Your Ref: 100636639-001
Our Ref: 23/02271/FULL

Application No: 23/02271/FULL
Proposal: Erection of workshop for car valeting (sui generis)
Address: Brenwood Suzuki Mitchelston Industrial Estate Waverley
Road Kirkcaldy Fife

I acknowledge receipt of your application for Full Planning Permission dated 16th August 2023. However, I regret I cannot accept your application as valid for the following reasons:-

PROJECT
Erection of steel frame structure for valeting of vehicles
DRAWING TITLE
Proposed Site Layout

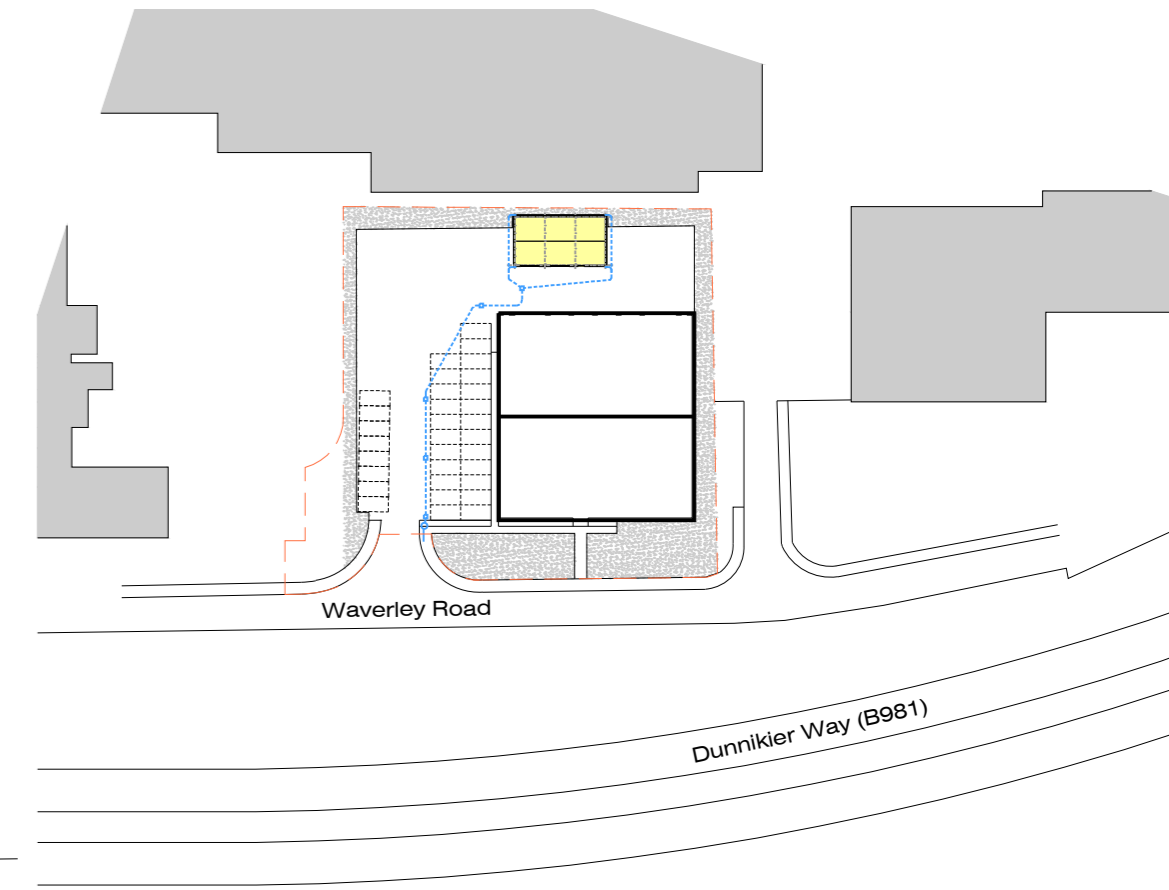
1. Although there may be existing drainage on site for the existing building the introduction of a new building may create issues in relation to surface water management. It is noted that you have indicated how the building would connect to the existing drainage layout, however there is a requirement to provide further detailed information on SUDS, including calculations, along with details of treatments to be submitted as part of this planning application.

You must complete the SUDS Compliance and Independent Check certificates (a Roads Construction Consent number is not required at this stage) which are contained within appendices 1 and 2 of Fife Council's Sustainable Drainage Systems (SUDS) - Design Criteria Guidance Note. Appendices 5 and 8 are also required to be completed.
